Subject: FP/36/12 - Extension of Temporary Access into Phase 1 of Felpham Development.

REV. No.	DATE	DESCRIPTION	INITIALS
Client			
David Wilson Homes			
BARRATT HOMES			
Project Felpham, Bognor Regis			
Title			
Temporary access into zone A			
Scale		Date	Drawing No.
As Shown		Jan 09	4180-530
Checked		Drawn	Rev
KIG		KIG

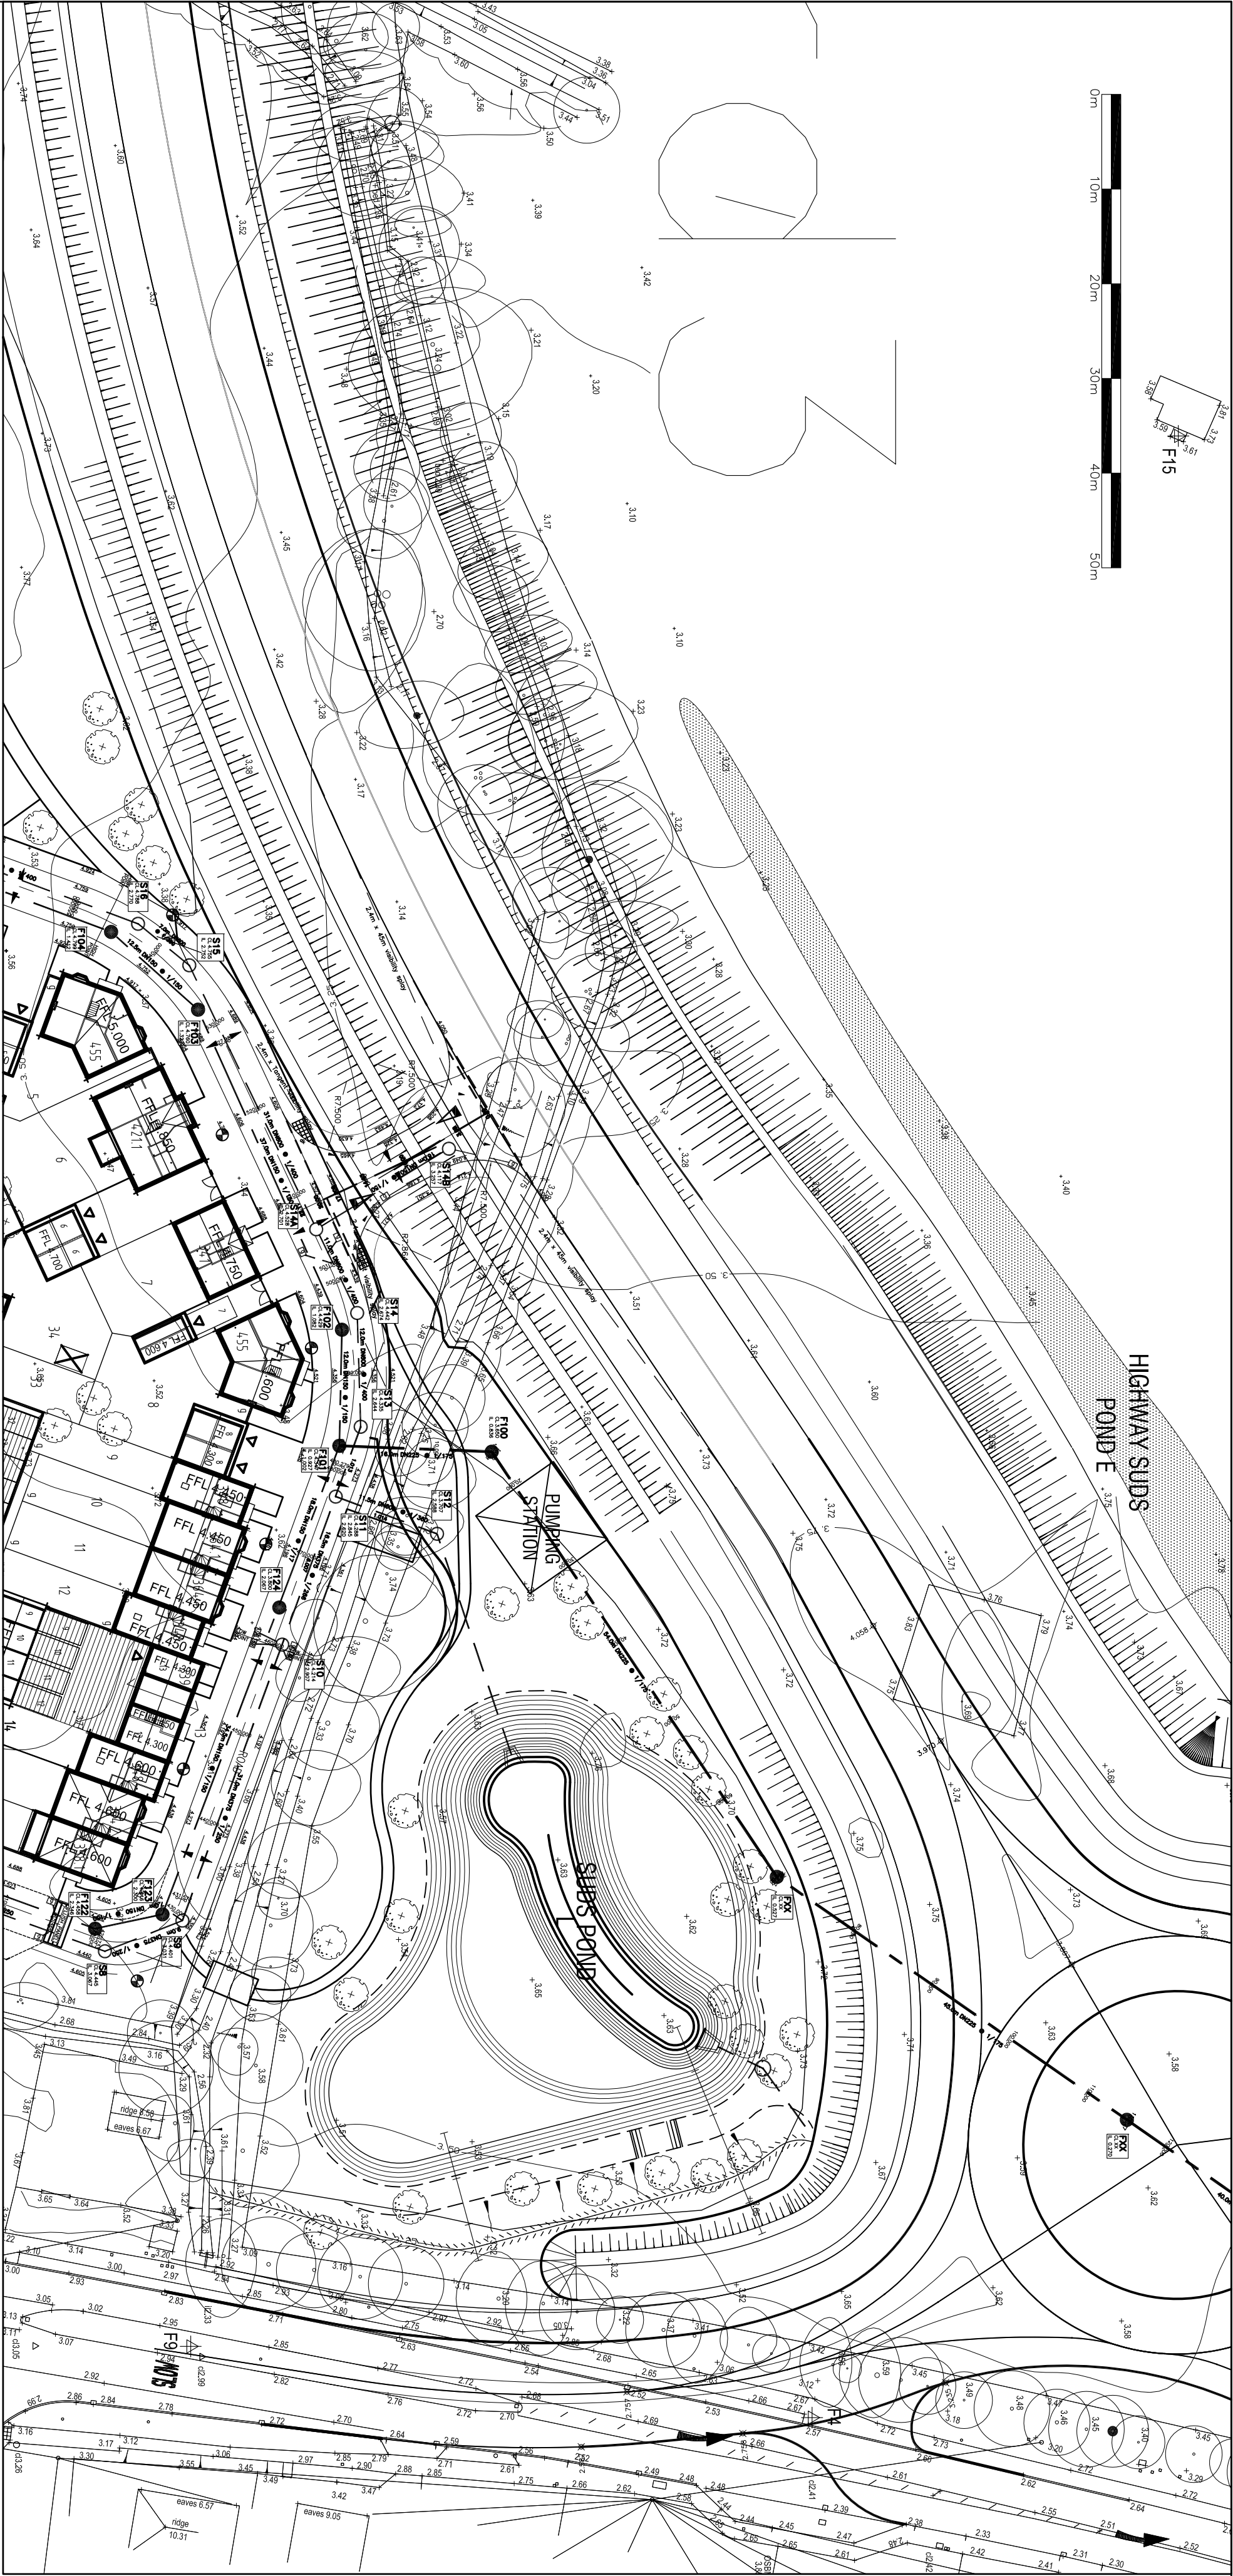
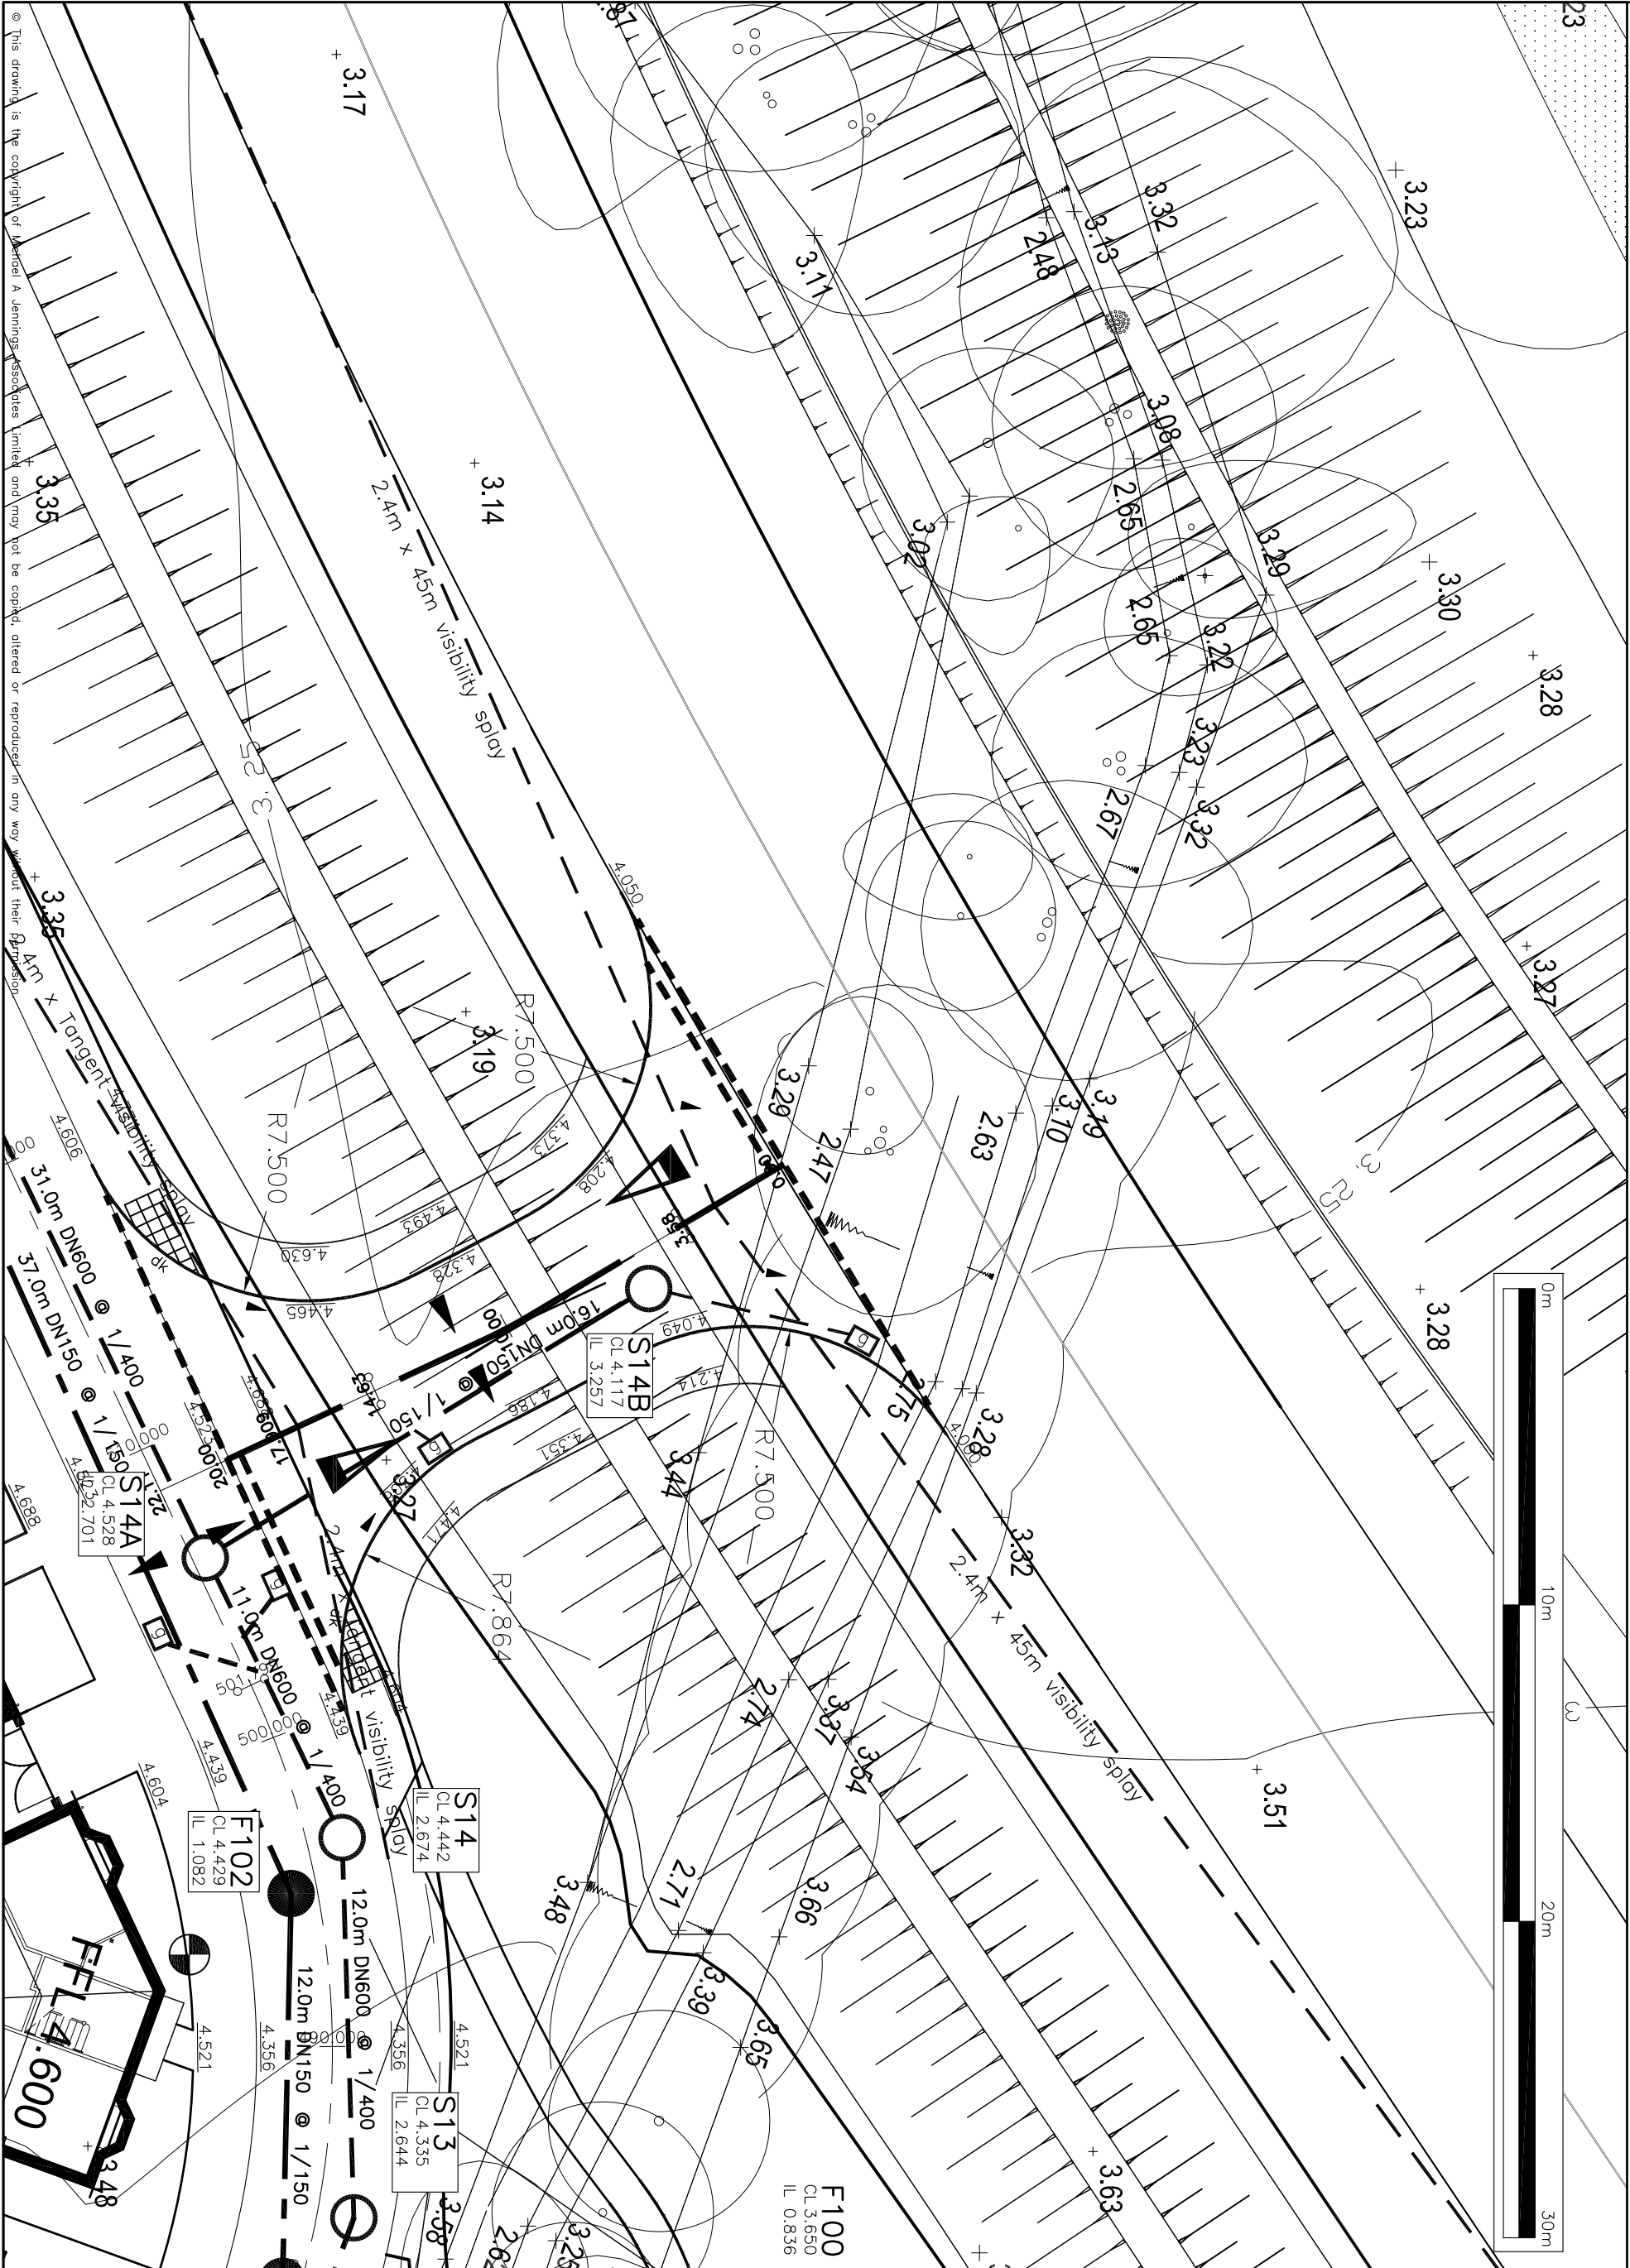
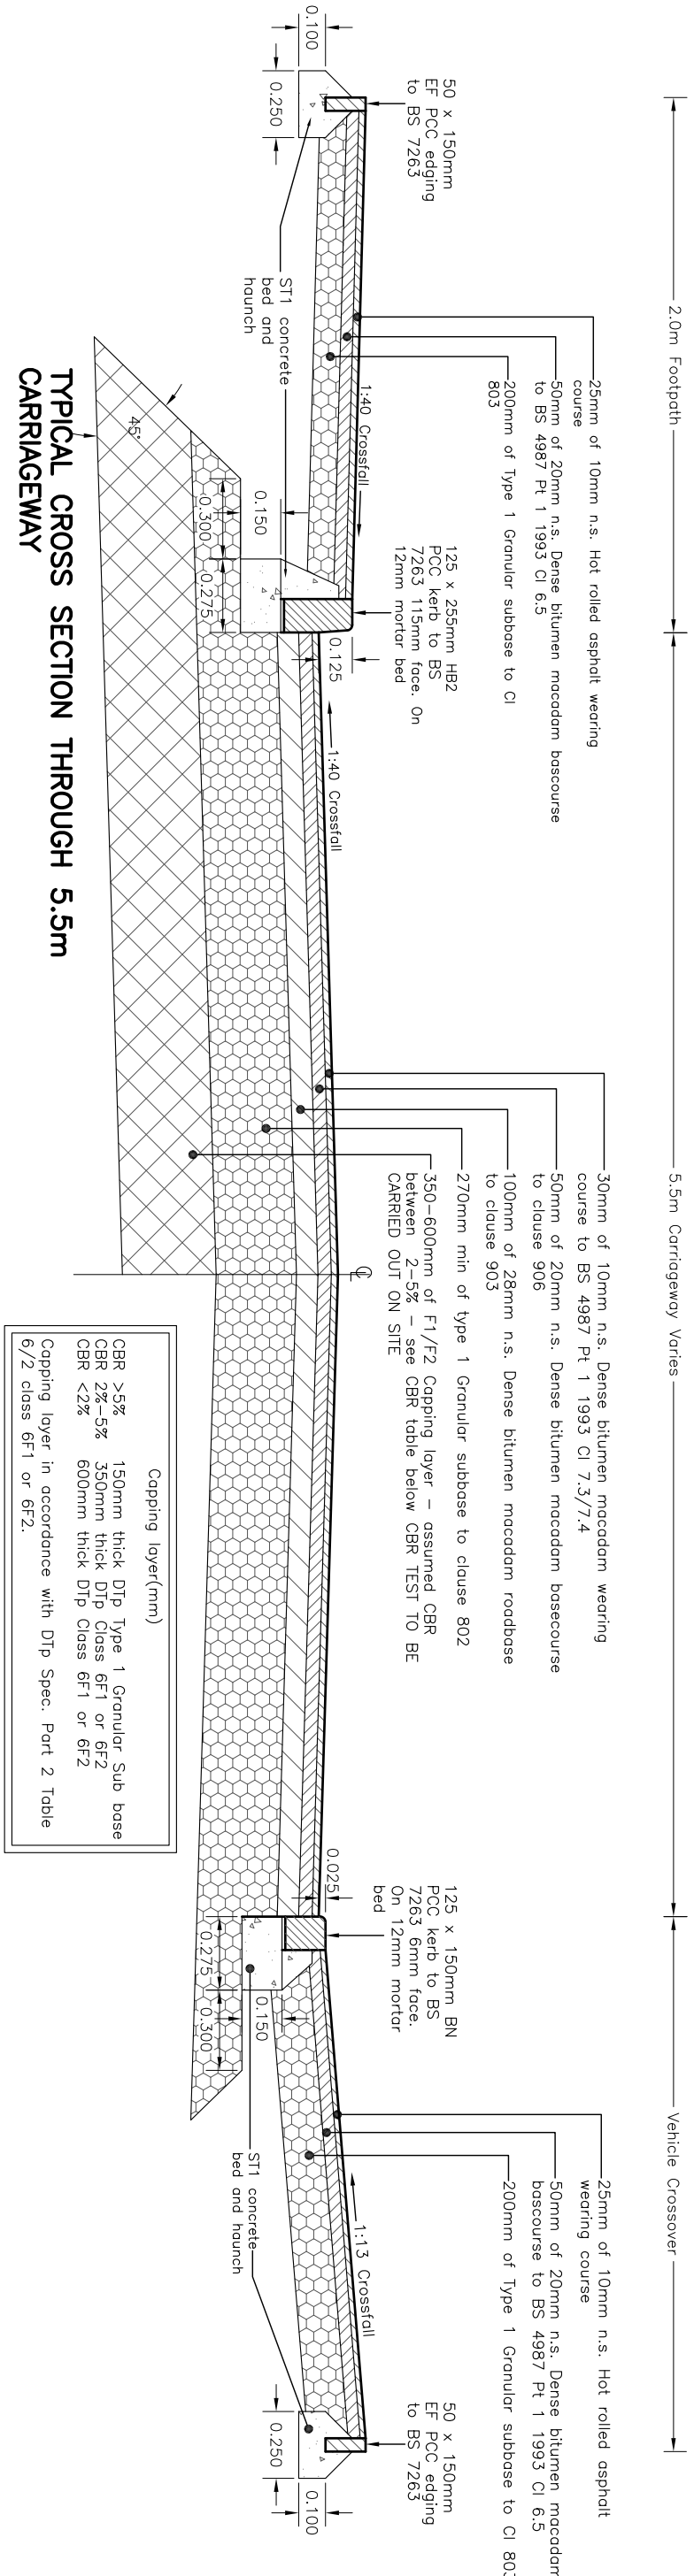
The County Council have raised an objection to the 18 month extension of the operating period of the temporary access into Phase 1 of your development at Felpham on the basis the available visibility is not appropriate for a new public highway with a 40 mph speed limit. The road will become a public highway once complete in November 2012.

However, if a drawing can be submitted that shows the requisite visibility standard can be met our position will be reconsidered and a revised response issued to Arun District Council.
